DECISION DELEGATED TO HEAD OF PLANNING

Application No: H17-0556-26 **Applicant:** Mr R Bright
Proposal: Proposed sun room to rear of dwelling with internal wall removal
Location: Ivy House Gosberton Bank Gosberton
Terminal Date: 28th August 2026

CASE OFFICER ASSESSMENT

SCALE	1:100	Comp Reg No.	06969616
DATE	JAN 2026	DRAWN BY	S.Andrews
JOB NO.	SA/ICTR/022/25	SHEET NO.	PP/5B/01/02
		REV	D

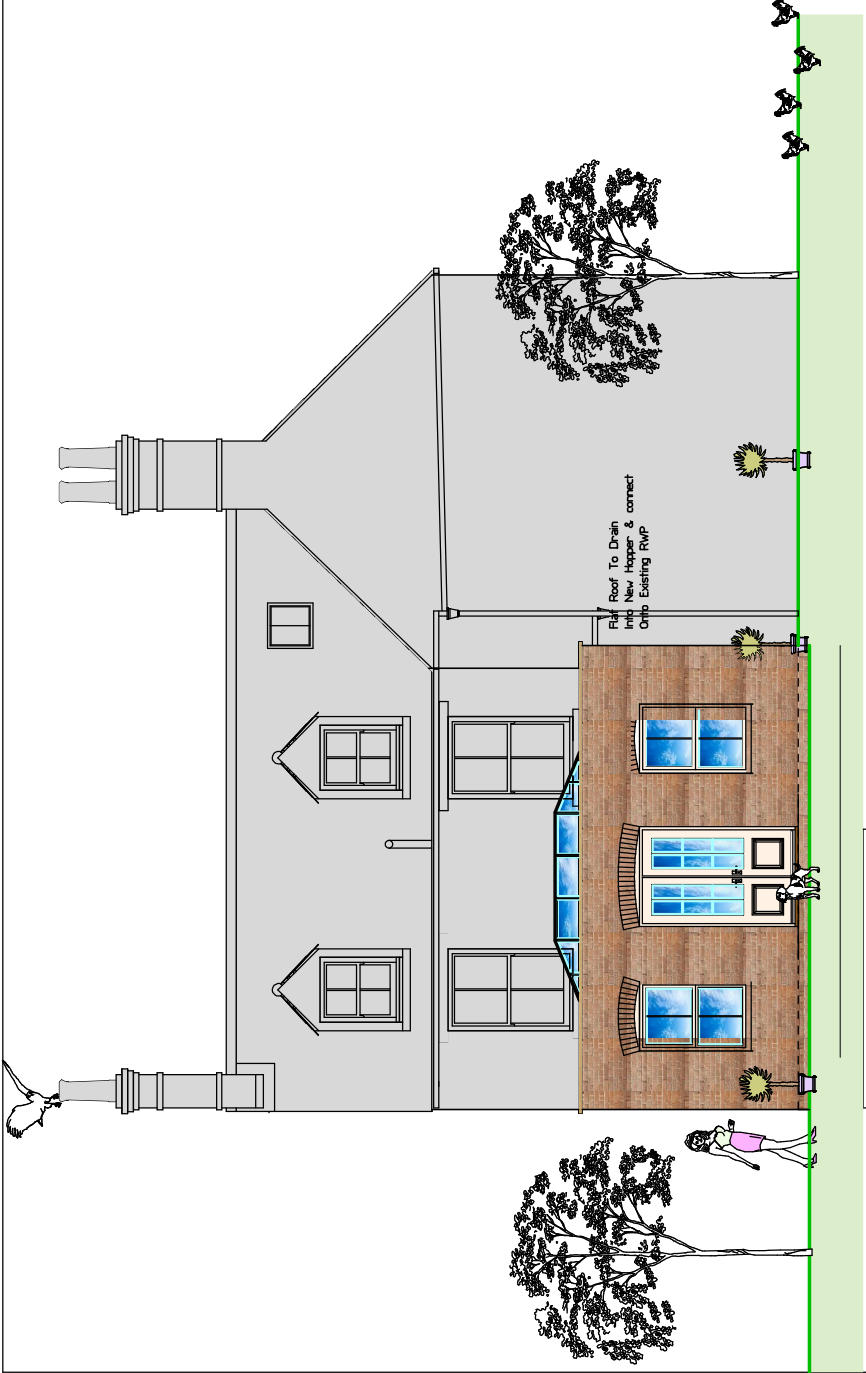
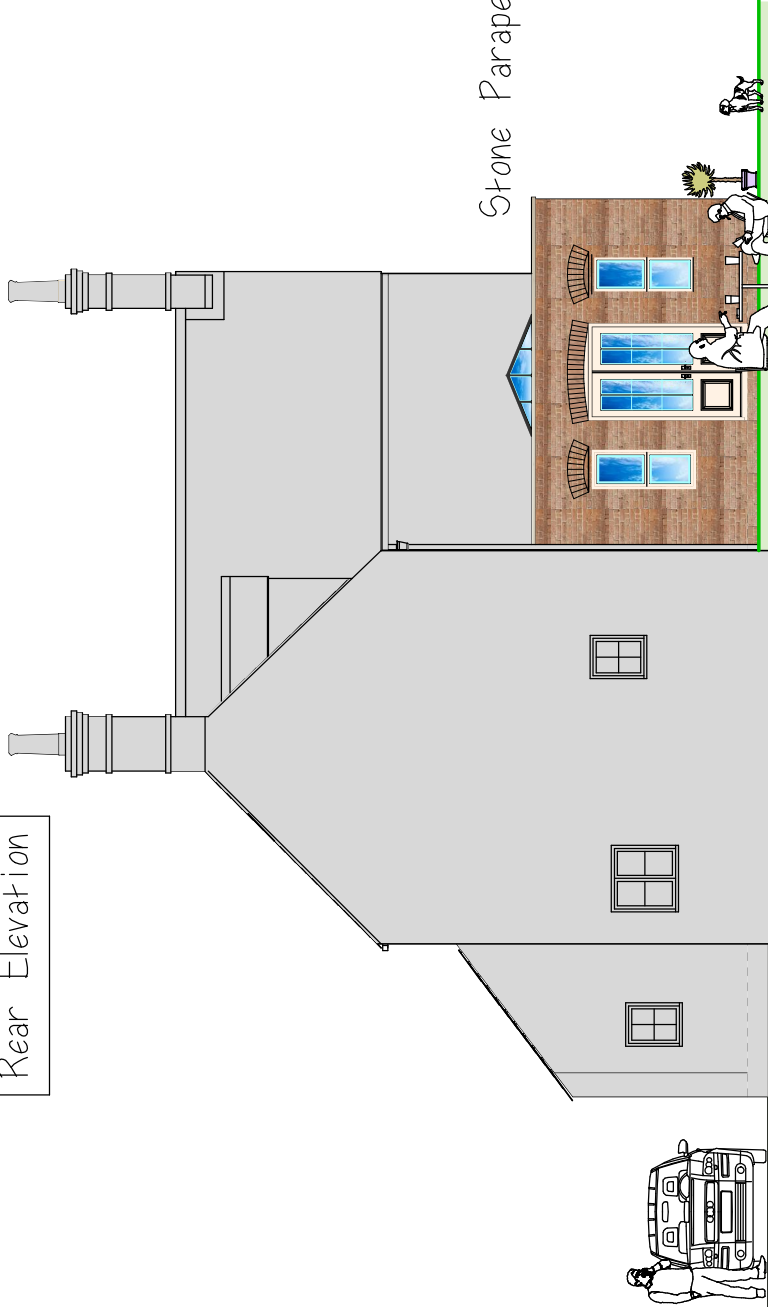
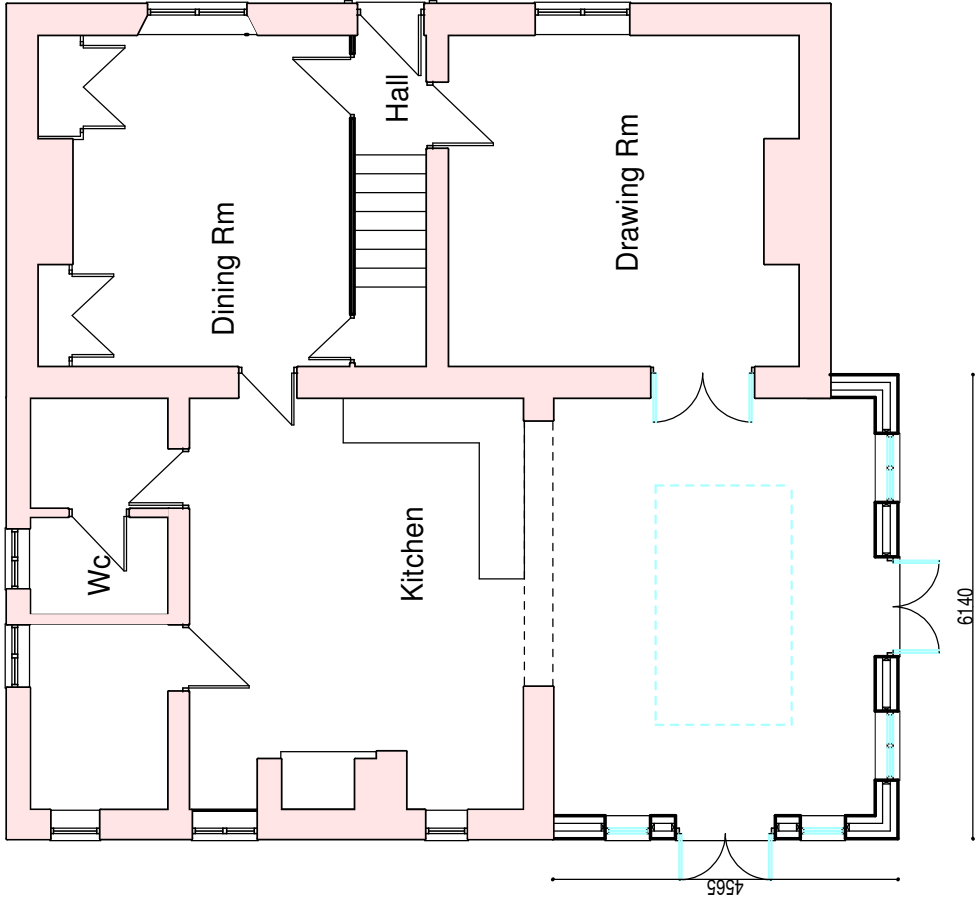
Firstly, I believe that the northwestern elevation can and should be brought out to sit flush with the side elevation of the property. As it stands, the proposal seeks to create a relatively awkward building geometry with multiple nooks and angles. By pushing out this elevation, it creates a less visually confused development without compromising on size.

Moreover, I would recommend that the windows be changed from side opening casements with a central meeting rail to a 2 over 2 sliding sash window. During the course of the previous application on site (refused) we discussed how several of the features that the applicant intended to utilise on their proposed extension were inappropriate features borrowed from the 1990s/early 2000s restoration work; this includes the casements which are not period appropriate to this building and less than ideal. I find it doubtful that should that be presented to the LPA today that the LPA would be satisfied by the introduction of such casements into the host building, and therefore, there is no reason, nor justification to permit them to be proliferated into an extension.

Moreover, I will need to see more detail of the proposed coping for the parapet (which should be authentic carved stone or possibly leaded), as well as full details of the proposed rainwater goods. It appears that the applicant proposes to make use of the existing RWGs on the rear elevation, but no details of this system are provided and nor are any elevation details presented for that return elevation - these must be provided.

No finalised details of materials have been presented. The "stone parapet capping" shown in the submission would be entirely inappropriate for this setting as it does not appear to be carved stone. A condition requiring the submission of materials should be placed upon any decision. These materials ought to be of the highest quality given the listed status of the building.

The extension is bulky and solid. The roof lantern, from the elevations provided, goes above the first floor window cills, creating an awkward arrangement. Likewise, the parapet would be virtually level with the cill, emphasising the bulk of the extension and reducing the integration. Moreover, the projection beyond the existing elevation would create an additional angle, and clearly mark the extension as a later addition, whilst also adding to the bulk of the dwelling.

I am satisfied with the design of the proposed extension, and as such, I am content that both the planning and accompanying listed building consent applications may be approved. However, this must be contingent upon the imposition of conditions to both applications requiring full details of windows, doors and a full and complete schedule of materials to be used.

I would also strongly recommend adding a note to any condition requiring details of the materials to be submitted which confirms and reminds the applicant that only the very highest quality of natural materials will be acceptable. For the avoidance of doubt, this should mean the avoidance of modern materials such as GRP for the flat roof, PVCu for rainwater goods, or cast stone for coping, for example.
